My Ref: D1755AIAL2

7th November 2017

**RE: AW/155/17/PL - BRUS LODGE, 28A KINGSWAY, ALDWICK, PO21 4DH
PROPOSED DEVELOPMENT**

Tree Retention and Protection Plan

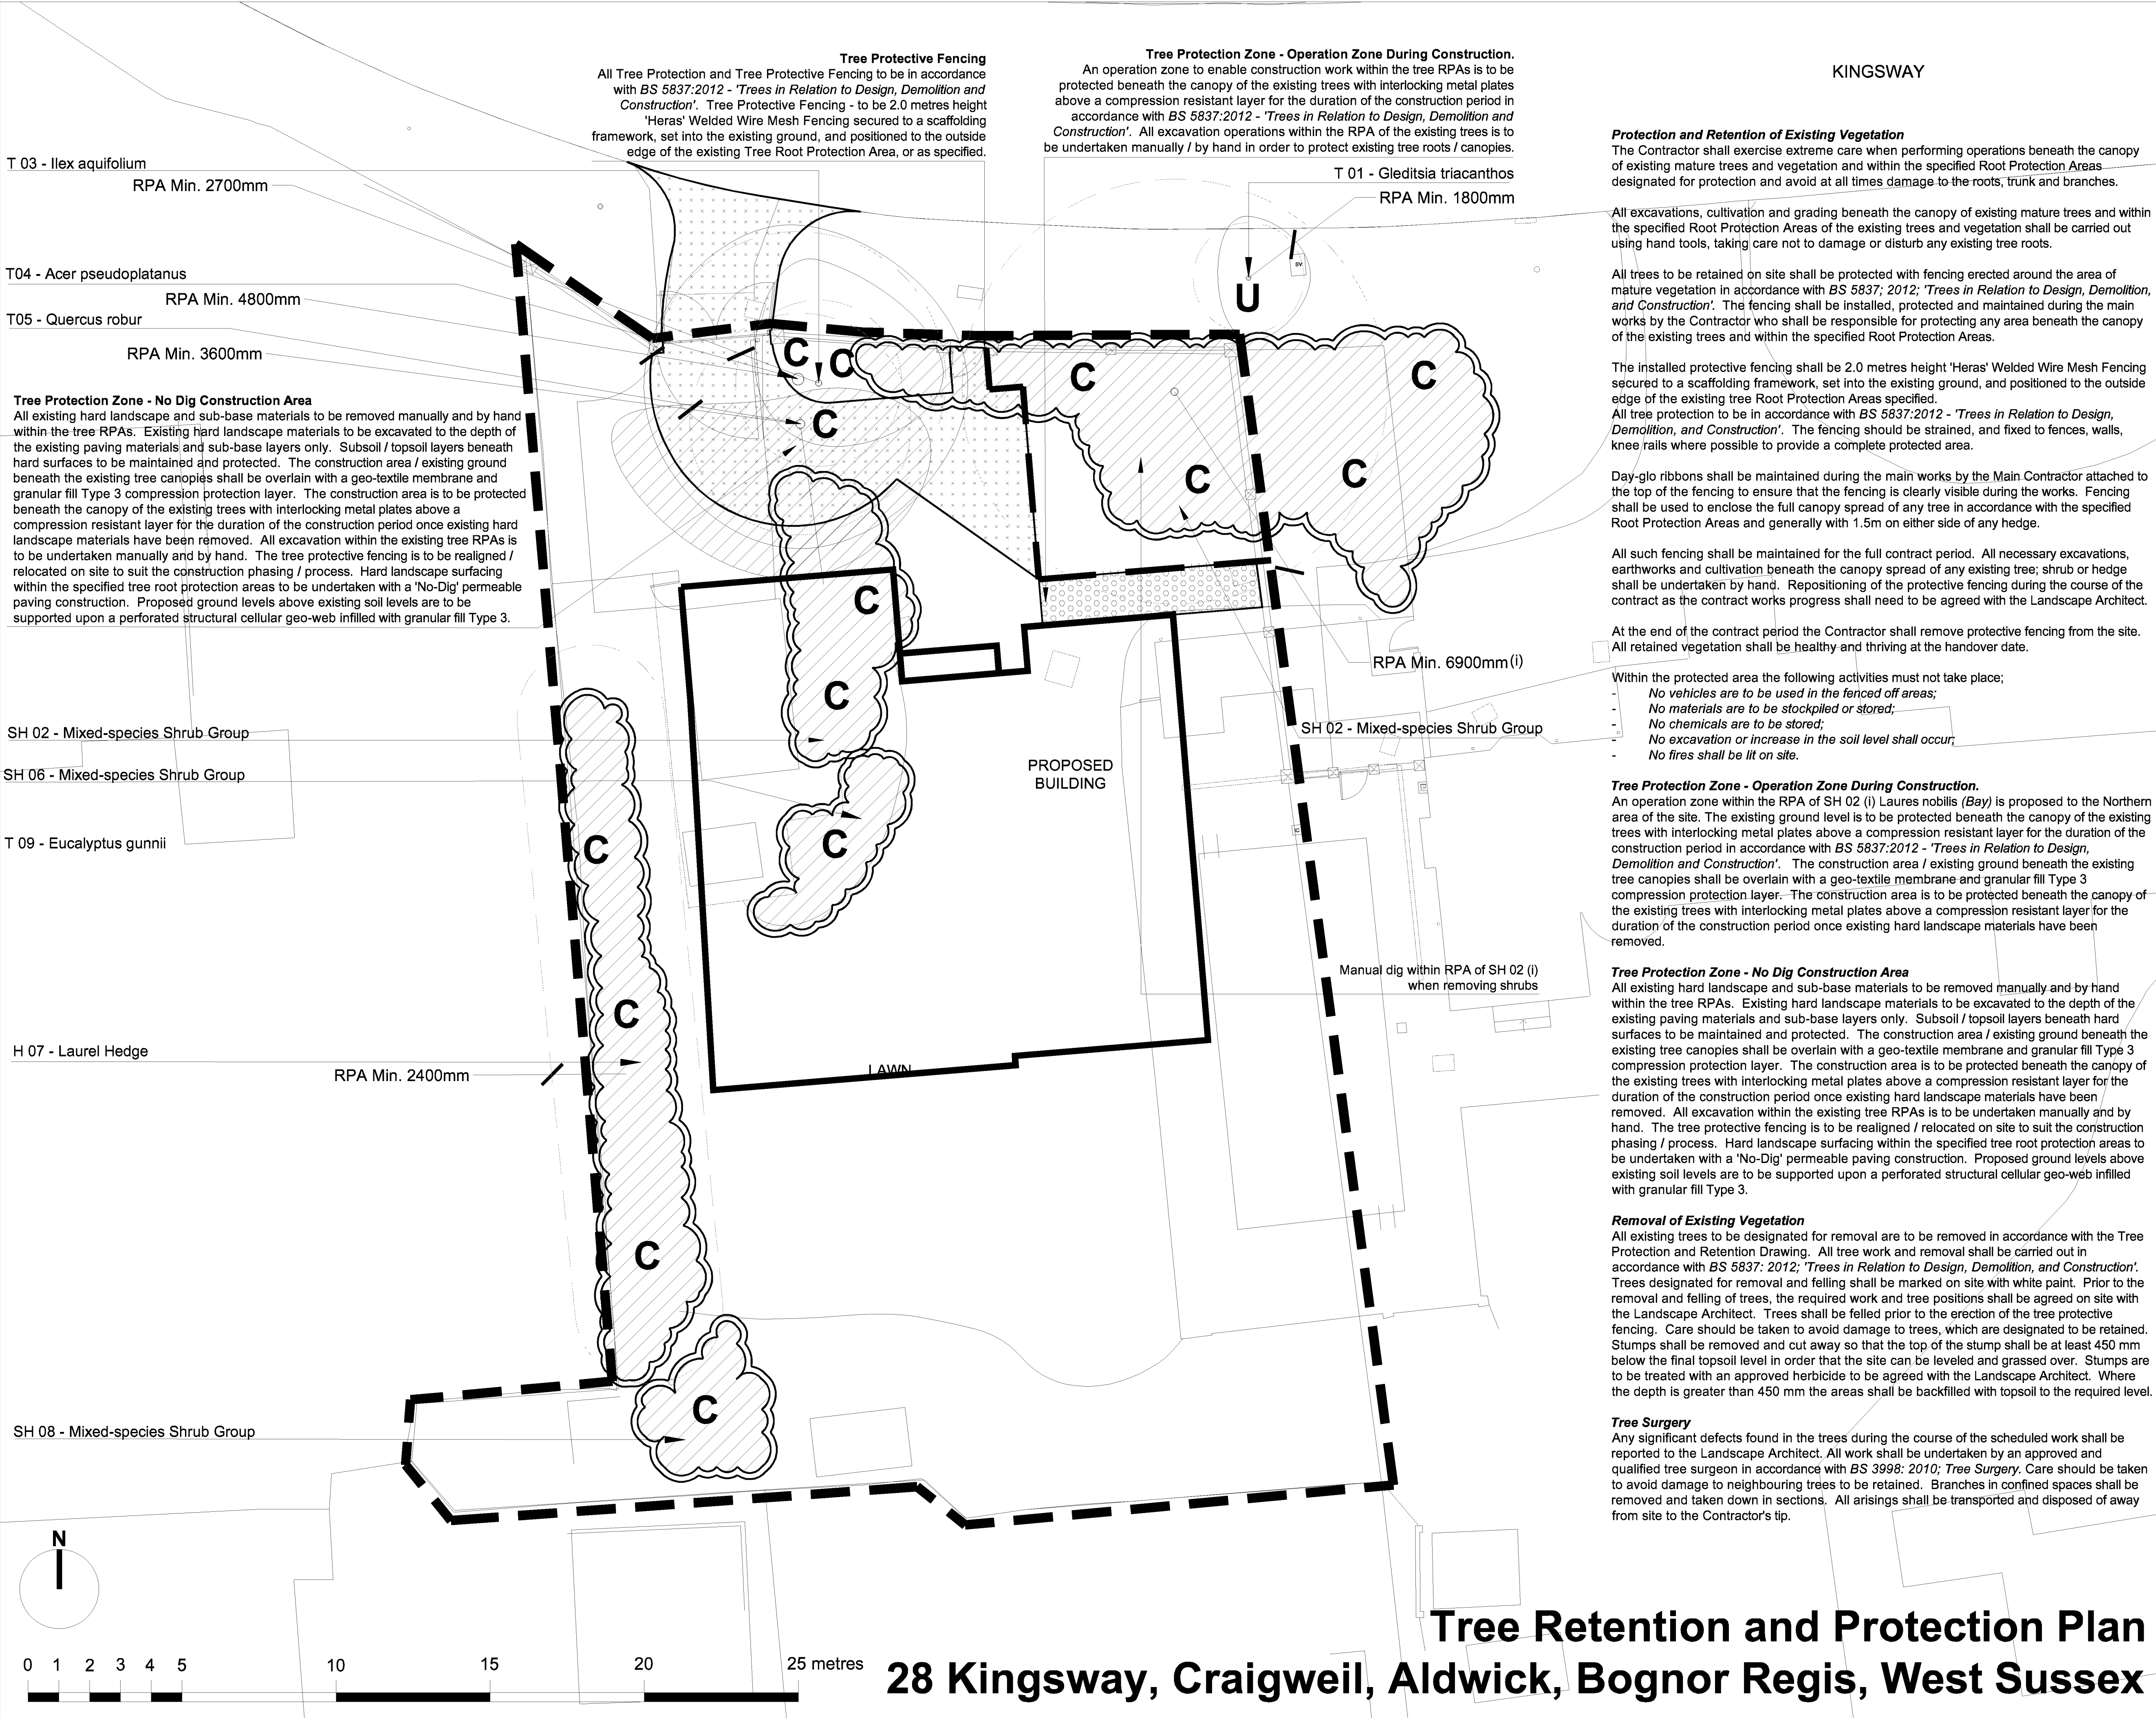
Tree constraints plan: The revised plan prepared by Lizard Landscape Design and based on the Seaman Partnership Ltd tree schedule informs the Lizard Landscape Design Tree Retention and Protection Plan (the Protection Plan) drawing no. LLD856/02 revision 3 dated 18.09.17. The plans show the proposed dwelling pulled back from the road compared with the previous layout, which has increased the space between the dwelling and the road front boundary. The Protection Plan is very full and detailed, to an extent that sometimes makes extracting the required information difficult e.g. where areas of shading or hatching overlap. However, there is additional information now compared with the previous submissions, and the tree protection measures are generally more comprehensive and practicable. I am now satisfied

that the submitted Protection Plan effectively incorporating a method statement are sufficiently clear and reasonably practicable and adequately address the issue of harm to retained trees. I am satisfied that the amendments constitute a workable proposal in tree terms, with sufficient details to enable the Council to apply a condition requiring adherence to the submissions, with such a condition satisfying the normal test for conditions.

Recommendations: I recommend that there are now no supportable tree grounds for this application be refused, subject to a condition requiring the development to adhere to the installed and process tree protection measures as set out in the Protection Plan drawing no. LLD856/02 revision 3 dated 18.09.17.
